Application No: M/91/21/PL
Site Address: 27 Central Drive Middleton-On-Sea PO22 7TT
Description of works: Variation of condition 2-approved plans & removal of condition 4-materials included on plans imposed under M/25/19/PL.

Thank you for your internet representation made on 28th July 2021 which has been recorded as an objection with the comments as follows:

PROJECT	27 Central Drive - Elmer Beach	DATE	16/09/18
TITLE	Proposed South Elevation	DRG NO	IBA/507/05
SCALE	1 : 50	REVISIONS	B

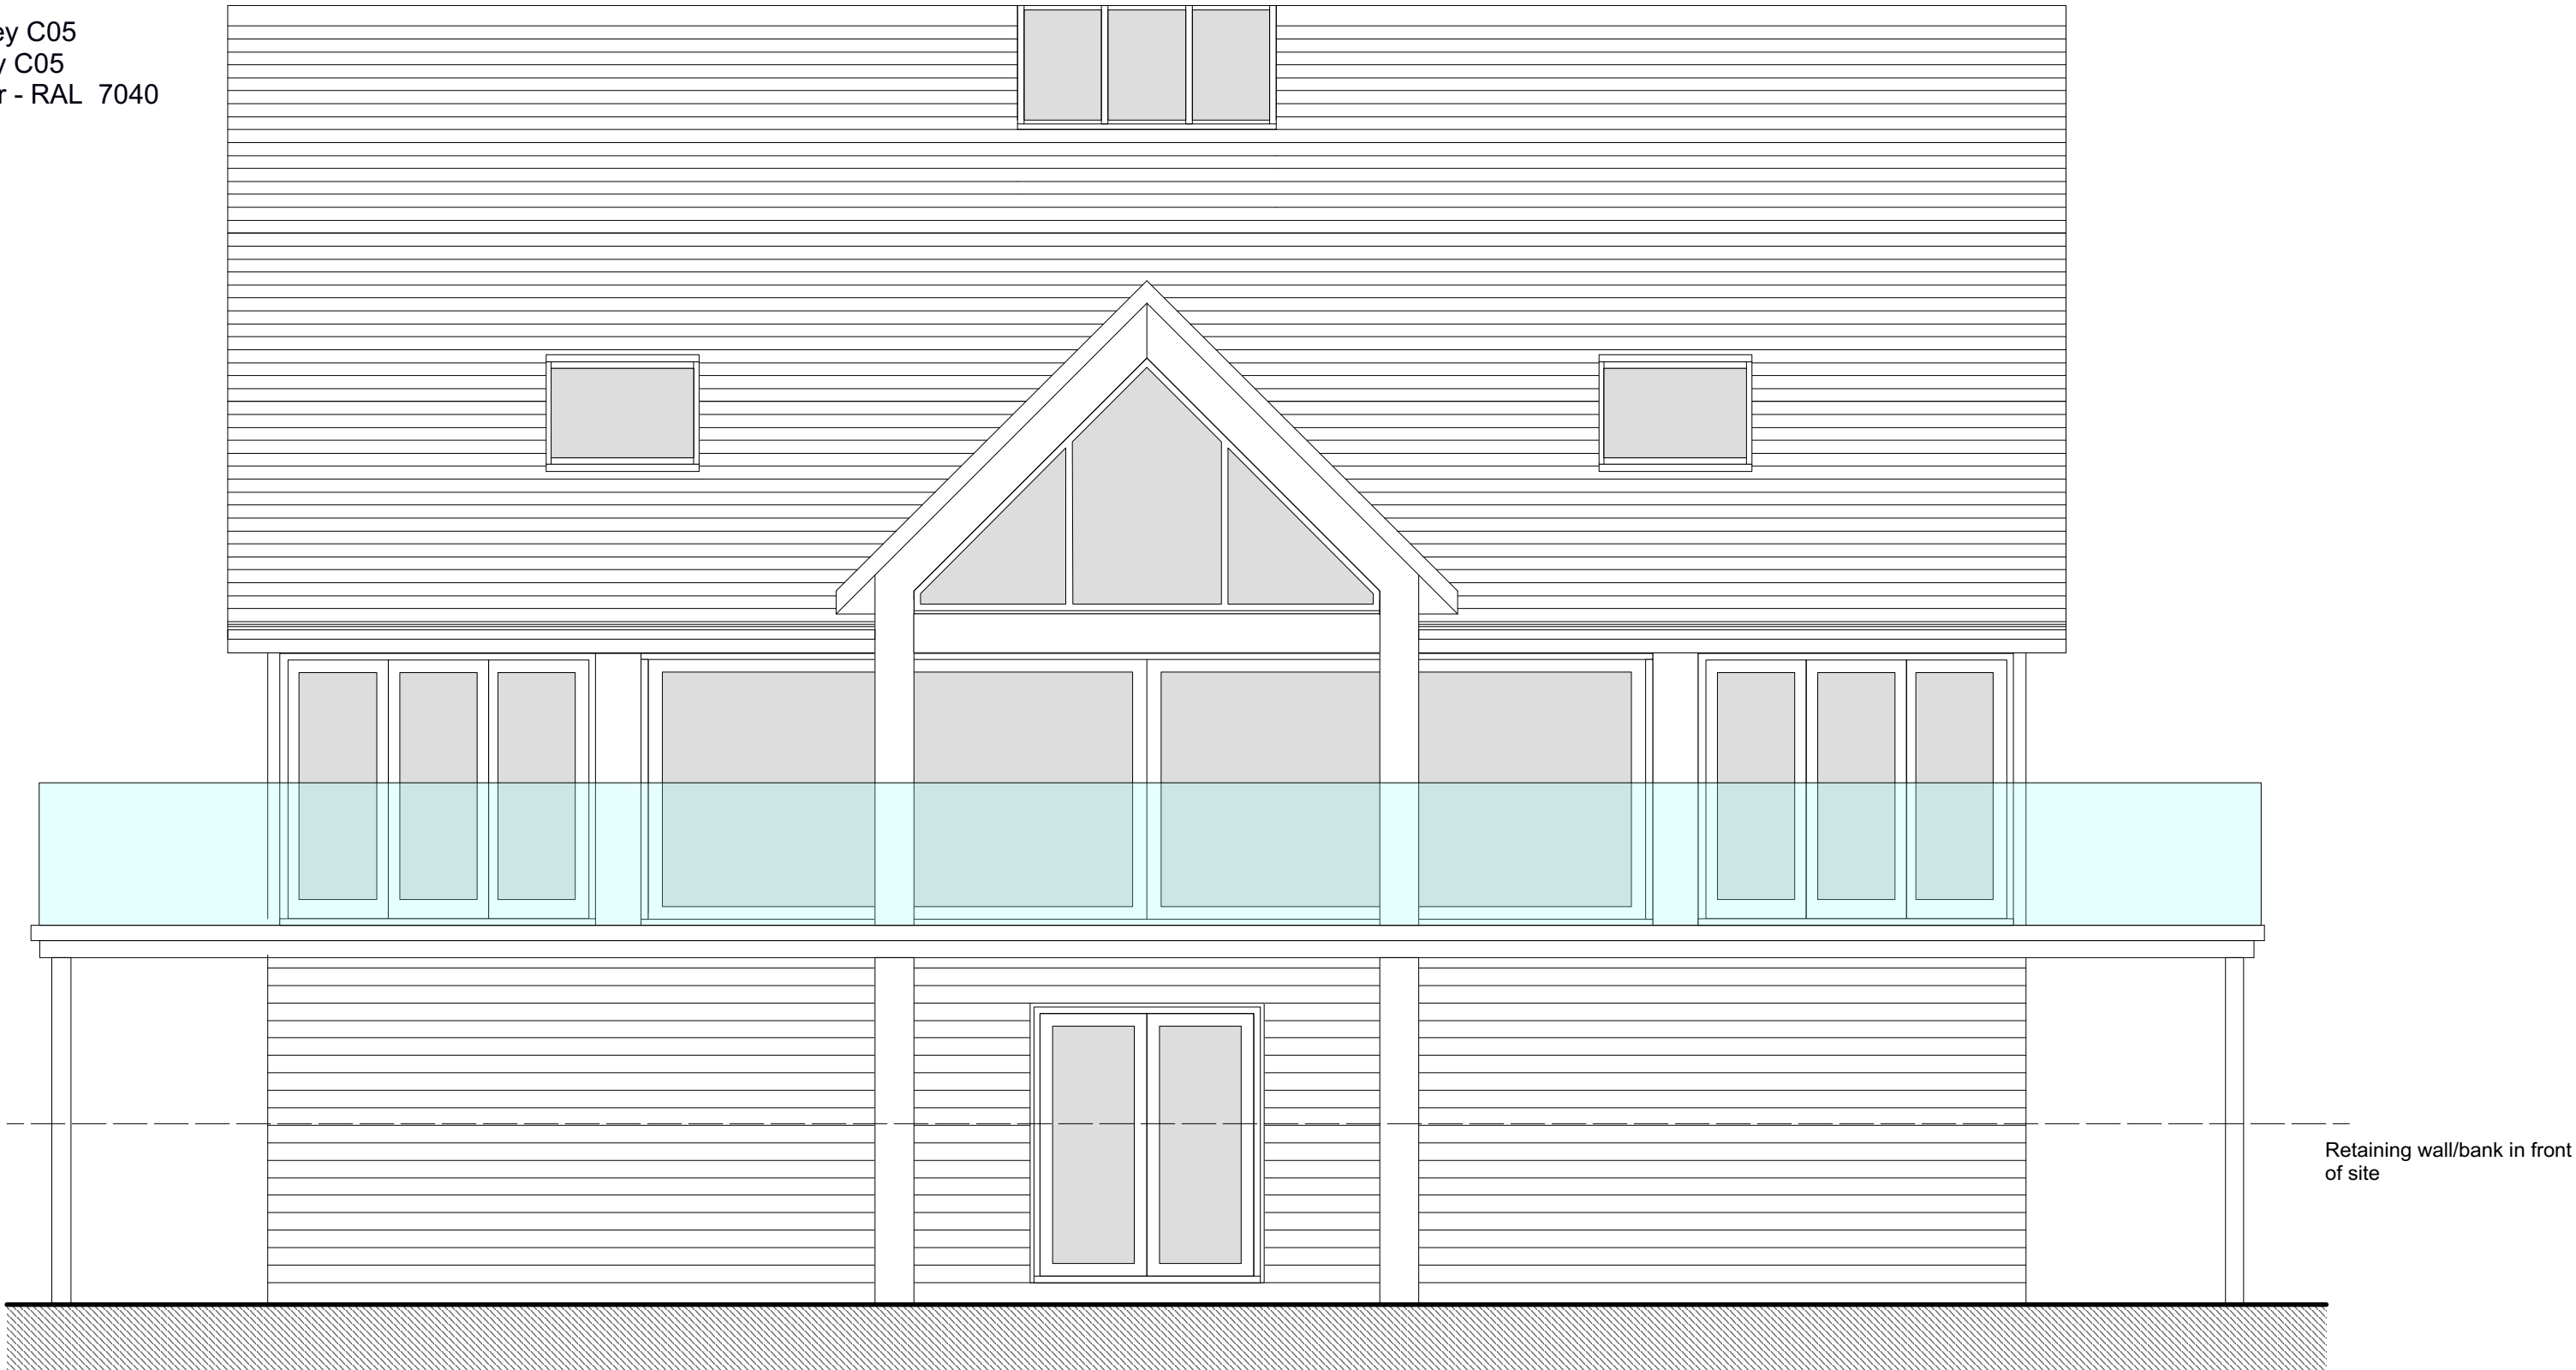
Building as now being constructed with the additional unsanctioned height will be out of character with the adjacent properties on the beach front and an unwelcome dominating feature along Elmer beach. Yet another example of developers exceeding their planning permission in the expectation of being permitted not to do something retrospectively that would not have been sanctioned if included in the original submission.
